11.14.2013

Thanks for the invite to the meeting last week; I thought it was a very constructive discussion. I just met with Kara and debriefed, and we came up with the following items that are still on our minds:

DRAWING NO. **C-10**

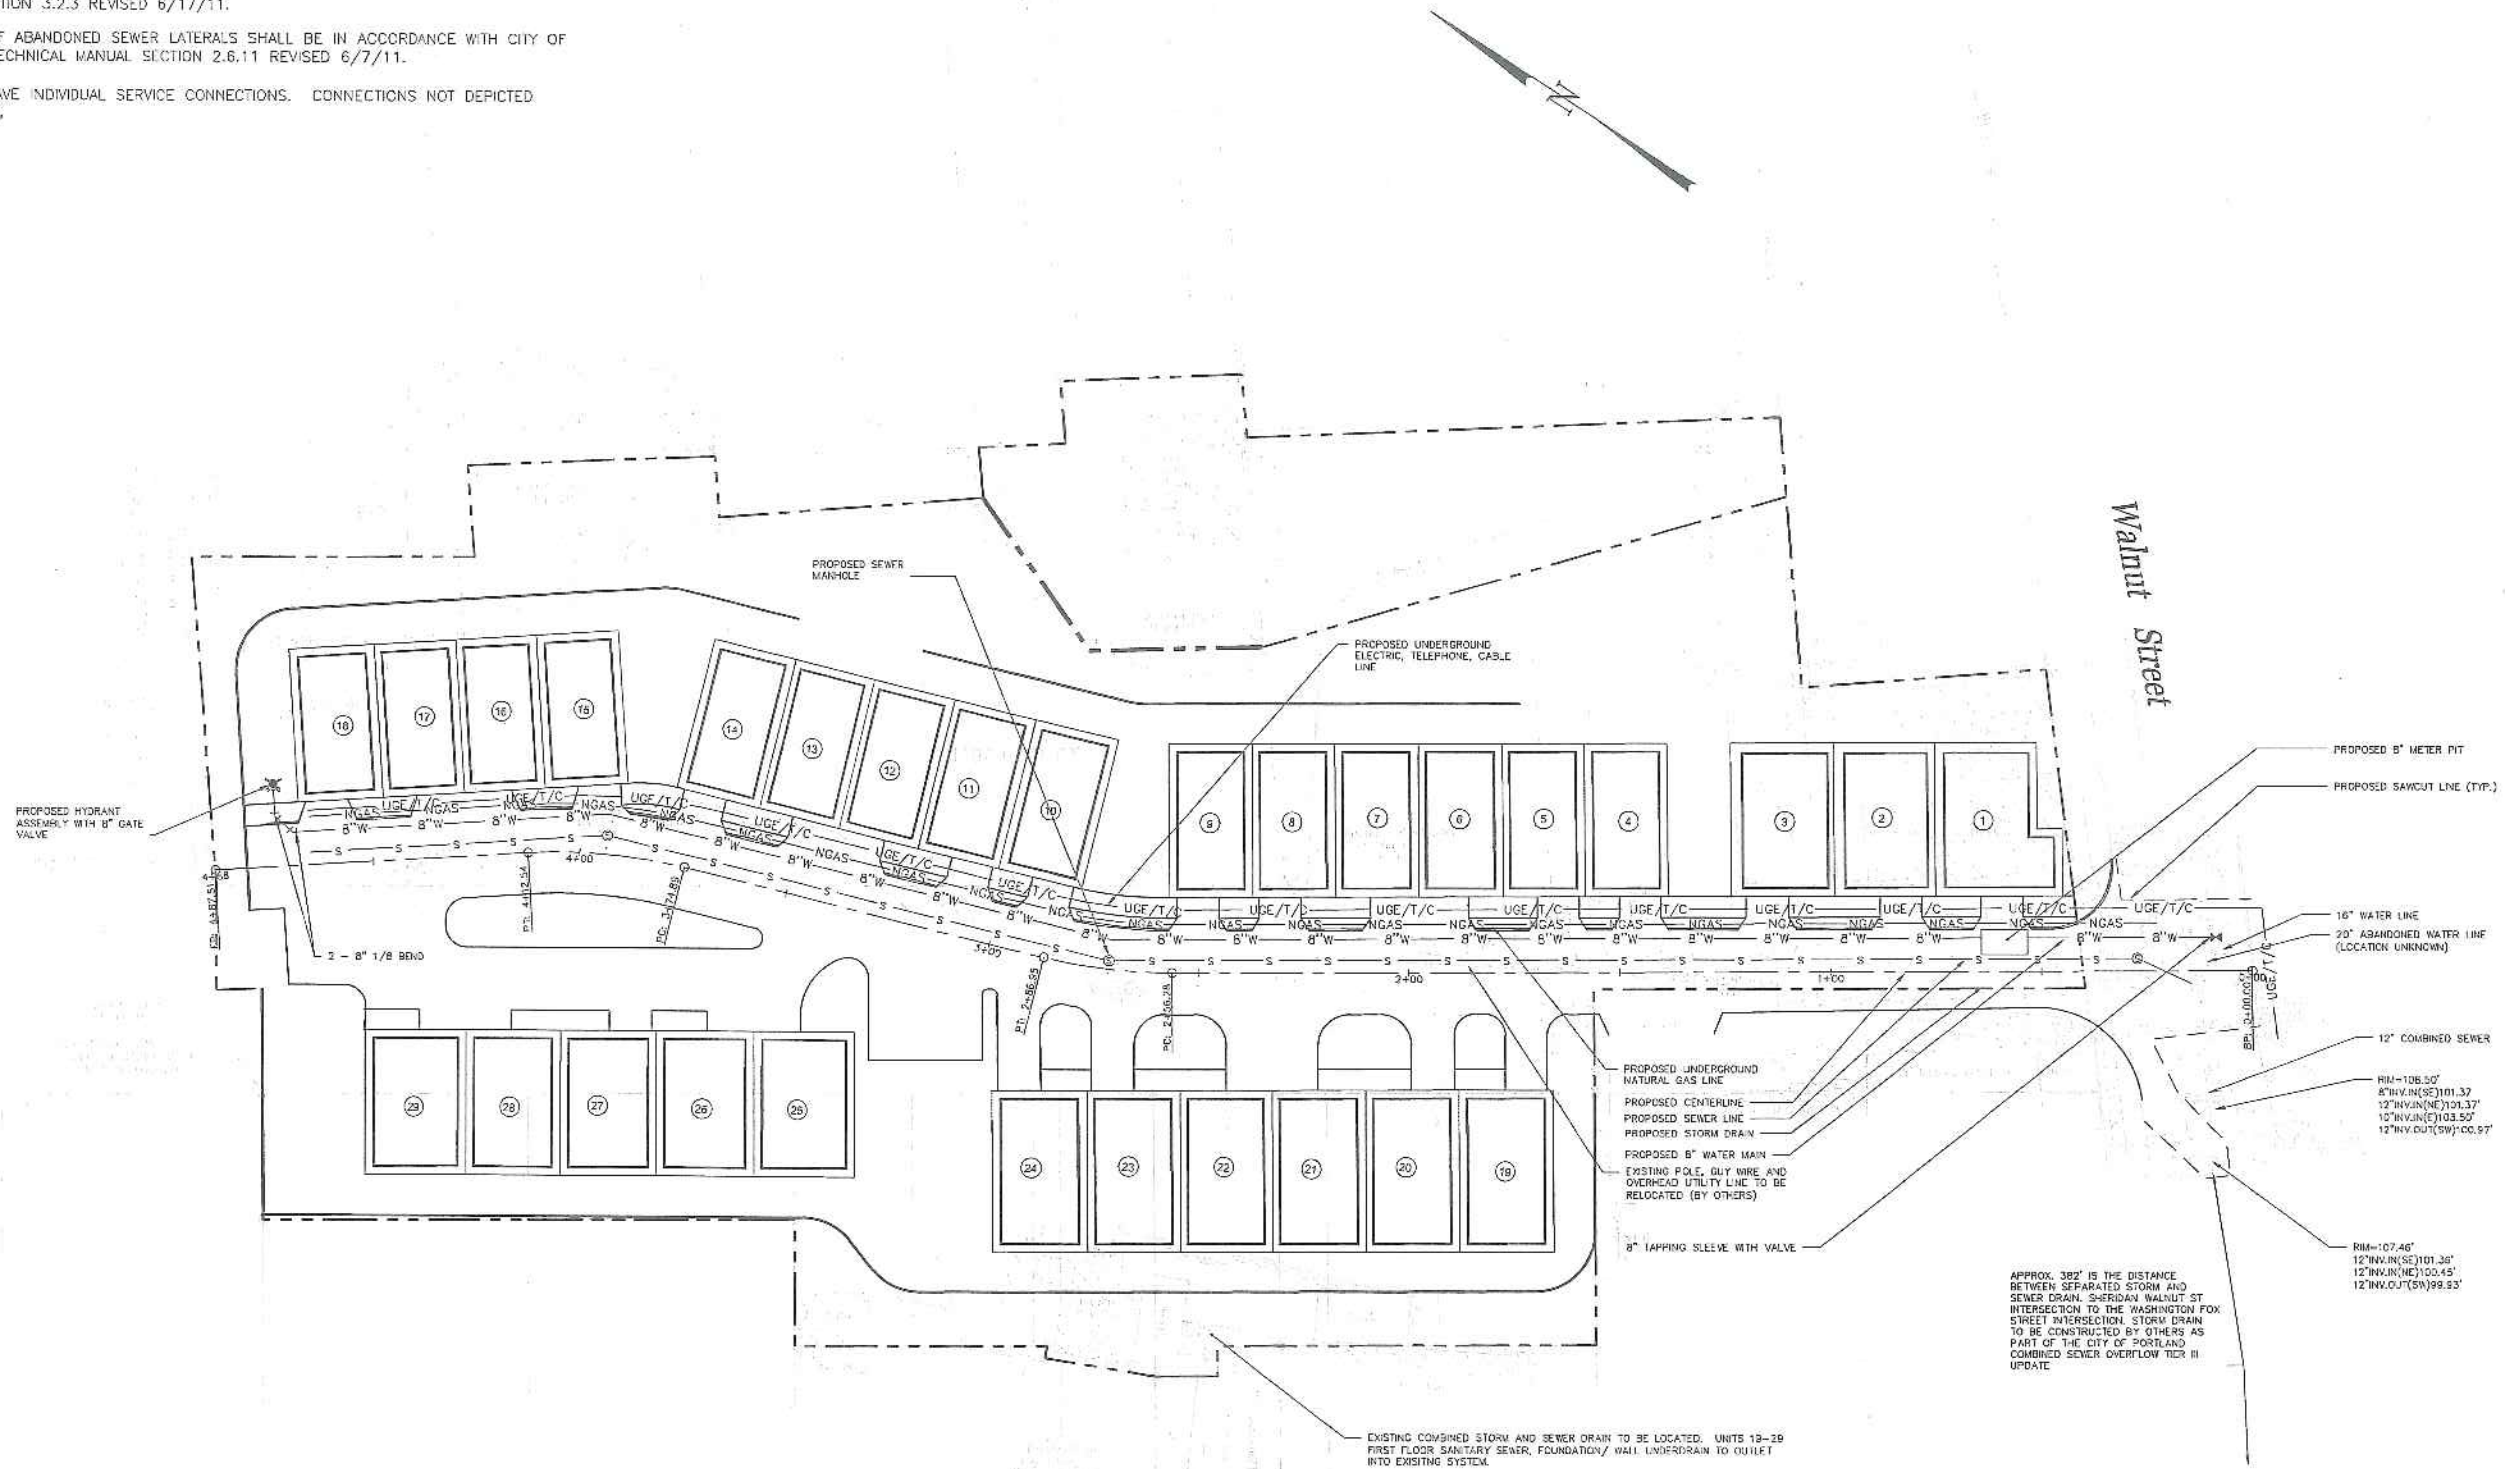
- Trail node at Jack Path - parked cars blocking visual access and compromising the pedestrian experience. Though we all think these spots may not be occupied much of the time, it would be unfortunate to find that they are occupied more often (by owners who may not want to pull into the garage all the time for example). It would be great to solve/mitigate this through design, and we look forward to seeing your latest thoughts on this. [*After writing this I saw the latest submissions to Planning, which show the bike parking near the trail head...which got me thinking, if you put the bikes elsewhere, could the cars be pulled far enough forward to not block the trail?.....could the steps be pushed any farther back to bring them more into the sight line and farther from the backs of the cars? ...*]

- We agree with Alex that if there are to be stairs to the Jack Path they should be a bit wider, maybe 6', and that there should be room for a bike ramp on the side. [*appears to be addressed in the new version - the bike ramp we can probably do 'after the fact', in the field.*]

- Large wall as the 'terminal vista' down the street. Though a green screen may help, this is still visually daunting. A transition to natural materials (boulders...) might help. We understand the area below the wall is also a vehicle turning bay for the last house, and we assume this is one of the temporary snow dump locations...?...that would limit what else you could do there, but part of this area has the potential to be an extension of the trail node - movable benches, planters..... some vertical elements to break up the wall? We're just brainstorming, and you guys are the experts, but it seems there might be some multi-purpose treatment options here.

- Trail to E. Cove - we're wondering if you have a stair/landing option where you showed a ramp. Something about the ramp seems less desirable...maybe it's more institutional? Seems more likely to be slippery too.

- At the top of the stairs from E. Cove - again you run into the parked car issue. Not sure what to do about it, other than to ensure there is a clear and welcoming path around both sides of the cars, to the woonerf. If this wasn't a place for cars, it would have GREAT potential as a larger node, given the elevation and view down E.Cove and over Bayside (great sunsets!). This can be done 'behind' the cars too, but won't be as much of a 'Place' as if you could incorporate the whole area.

- Bike racks - we still think there should be a few 'guest' bike racks/spots; ideally near the trail nodes. I would think these could be ornamental vertical elements that fit into the landscape, that happen to be good bike racks, rather than stand alone boring bike racks with requisite space-hogging concrete pads. [*see them in the new plans...they do take up valuable space...I've seen some 'wall mounted' types, and others that take less space...*]
